Application for Removal or Variation of a Condition following Grant of Planning Permission or  
 Listed Building Consent

Planning Permission - Erection of 2no. detached warehouse buildings divided into 3no. units to use under Class B8: Storage & Distribution of the Town & Country Planning (Use Classes) Order 1987 as amended, relocation of 4no. storage containers and provision of additional hardstanding area.

S/023/01858/18

Two

DRAWING	Proposed Block Plan	DATE	June '21
CLIENT	Az Property	SCALE	1:100
DRAWING No.	724/D/04	DRAWN	J.H
REV.	B

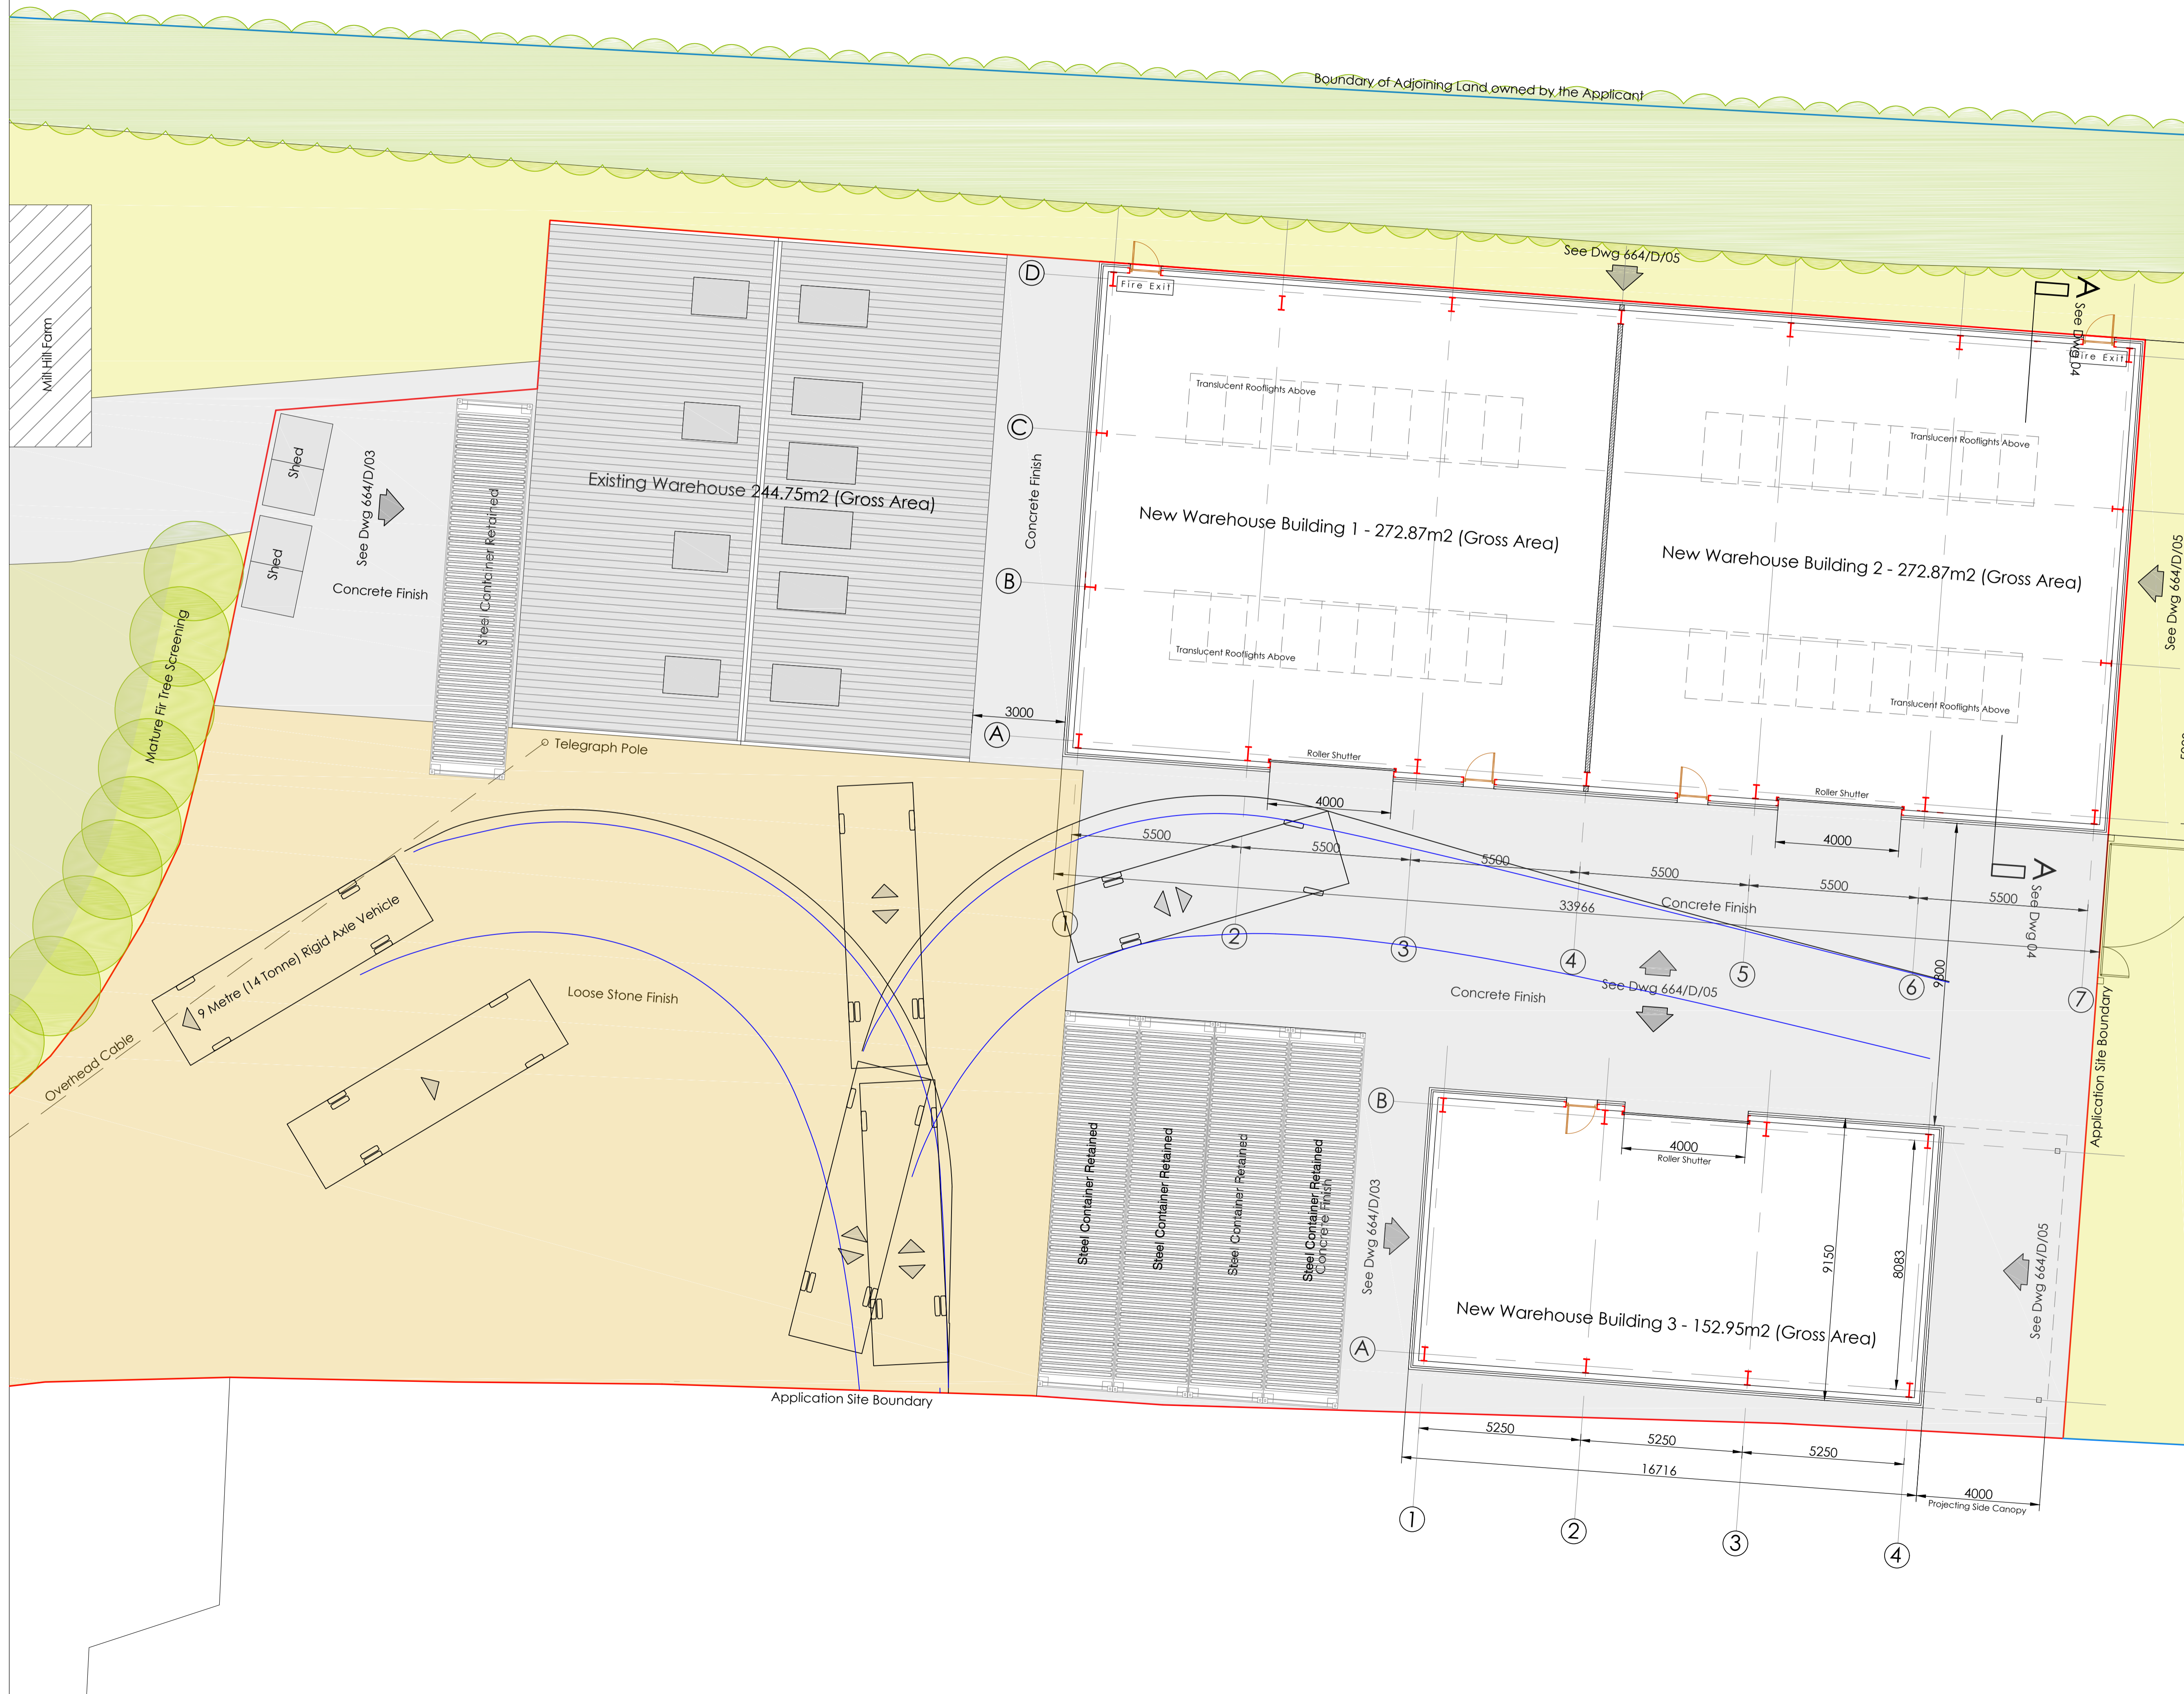
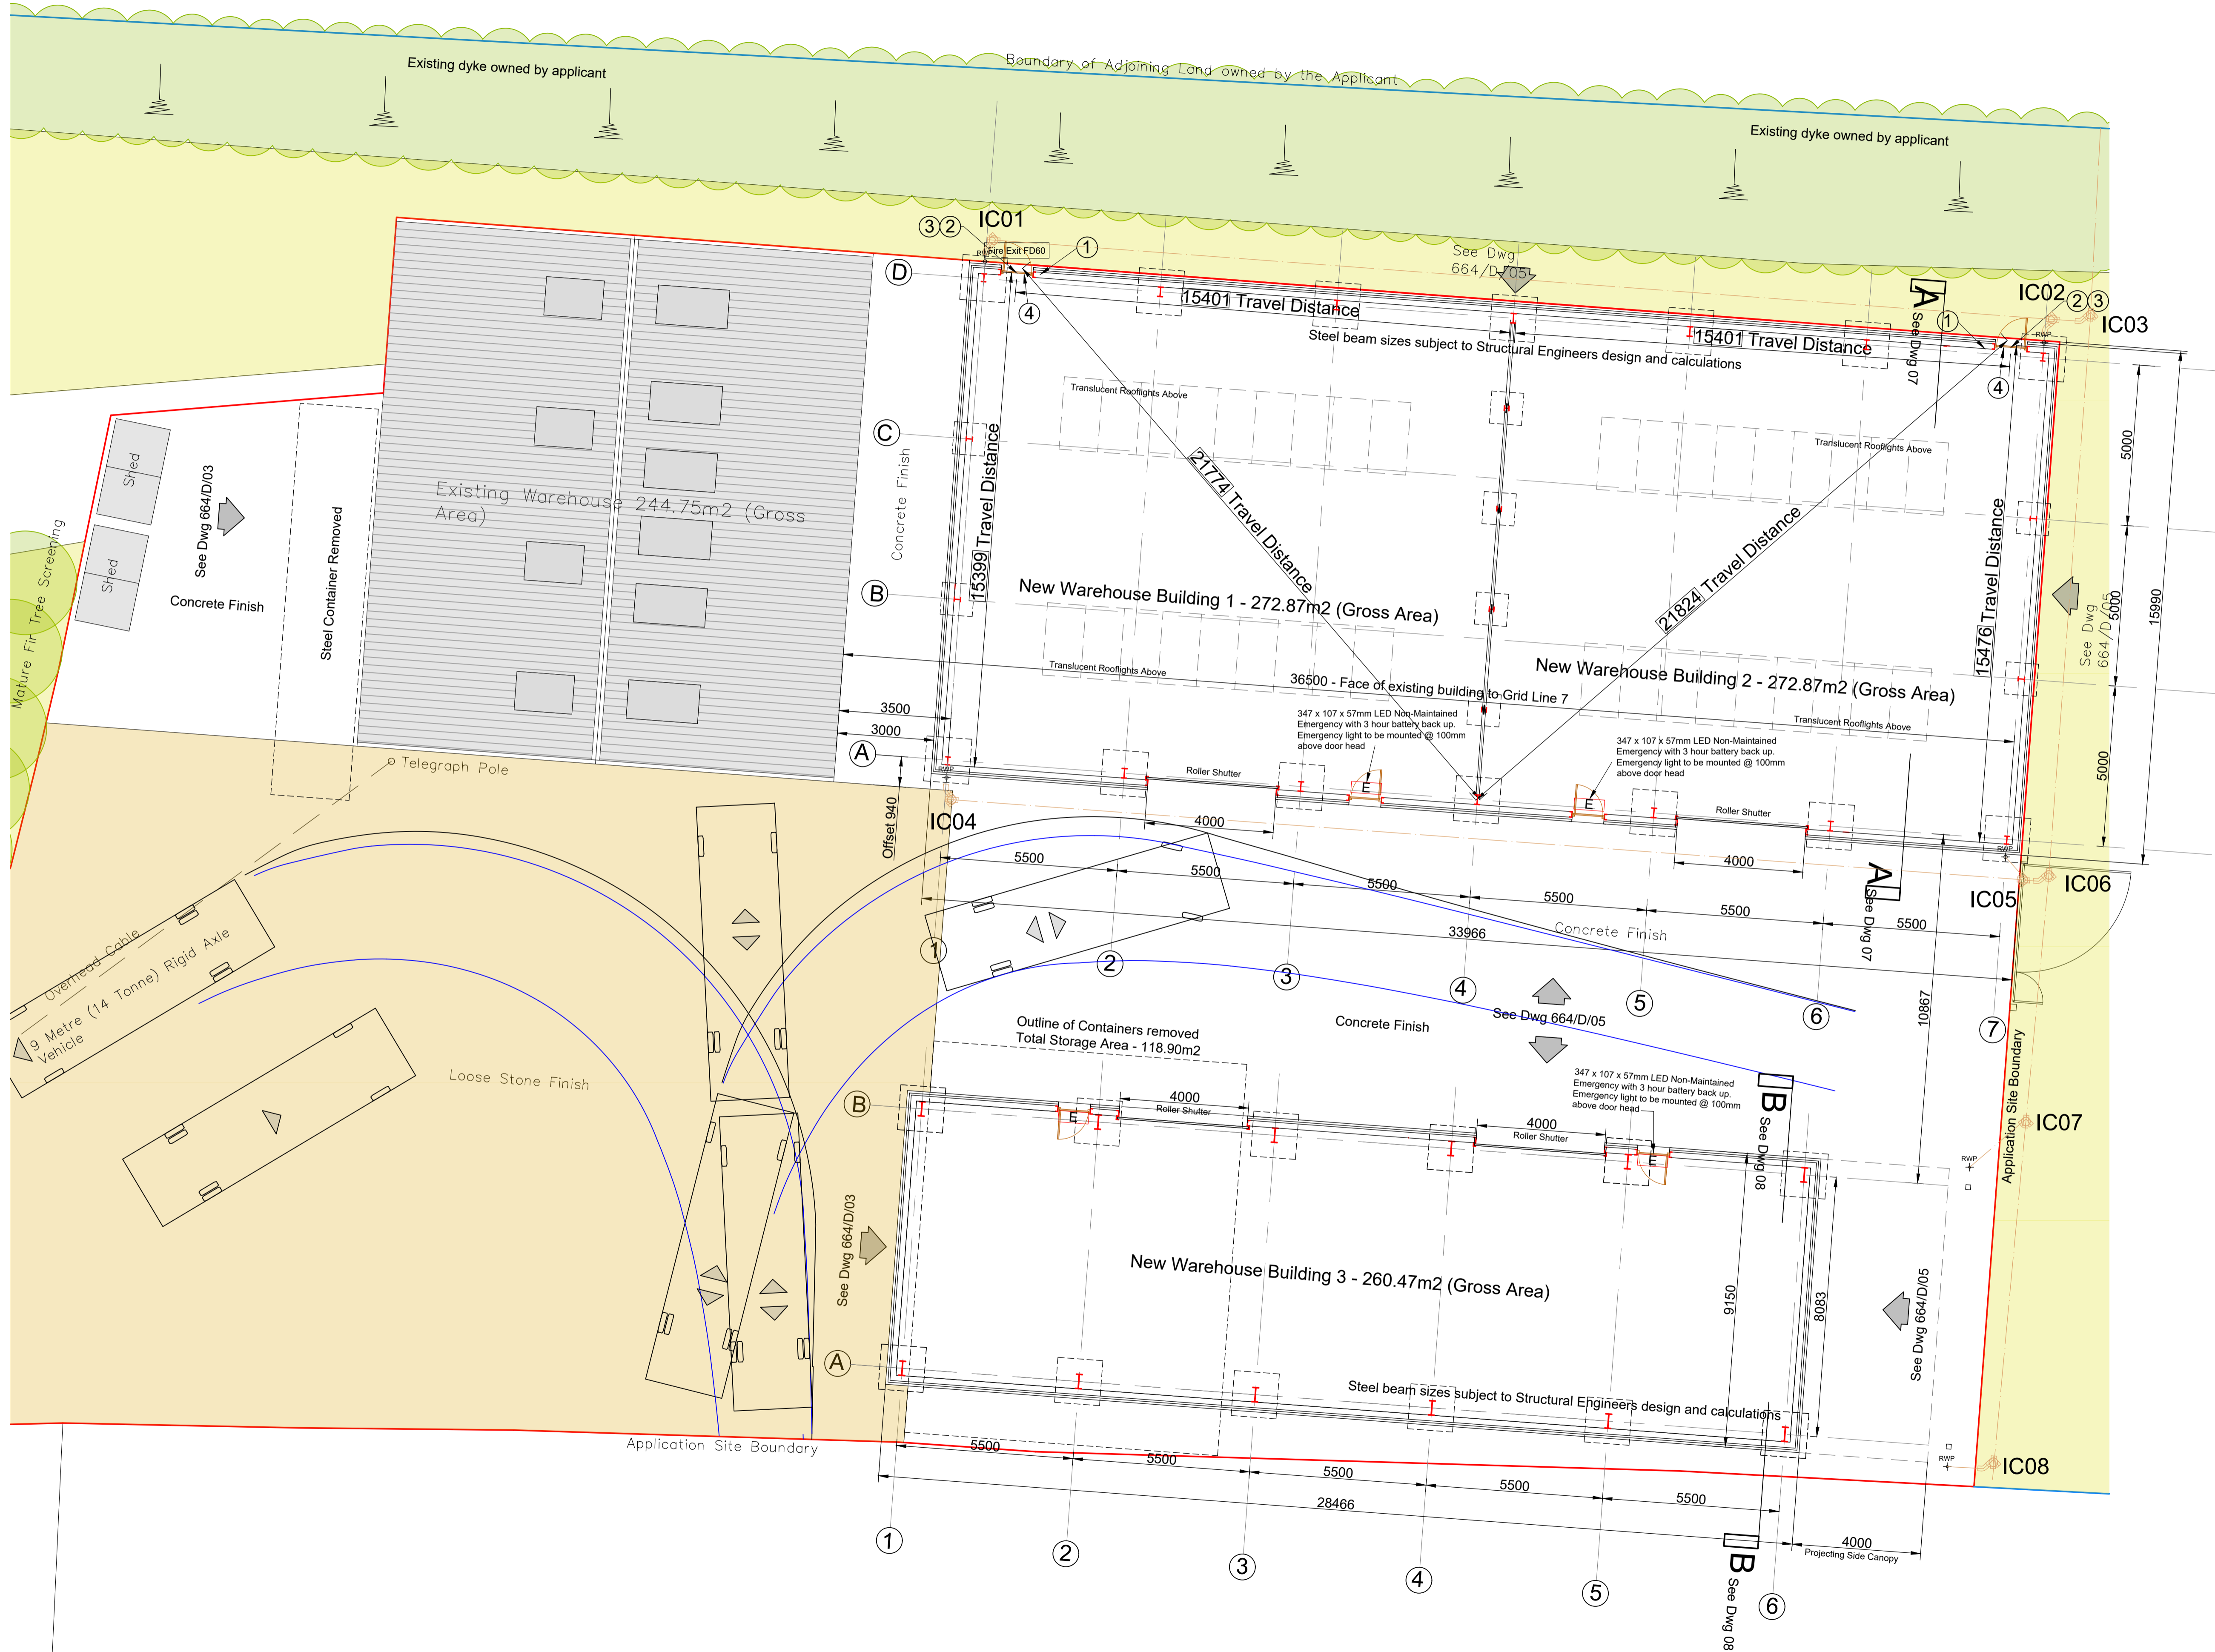
It is more practical and logistically more efficient to store goods in a single warehouse than a warehouse and 4 individual containers.

Delete the following approved plans;

Plan No. 664/D/04 Rev A Received by the LPA on the 17/09/2018

Plan No. 724/D/04 Rev B
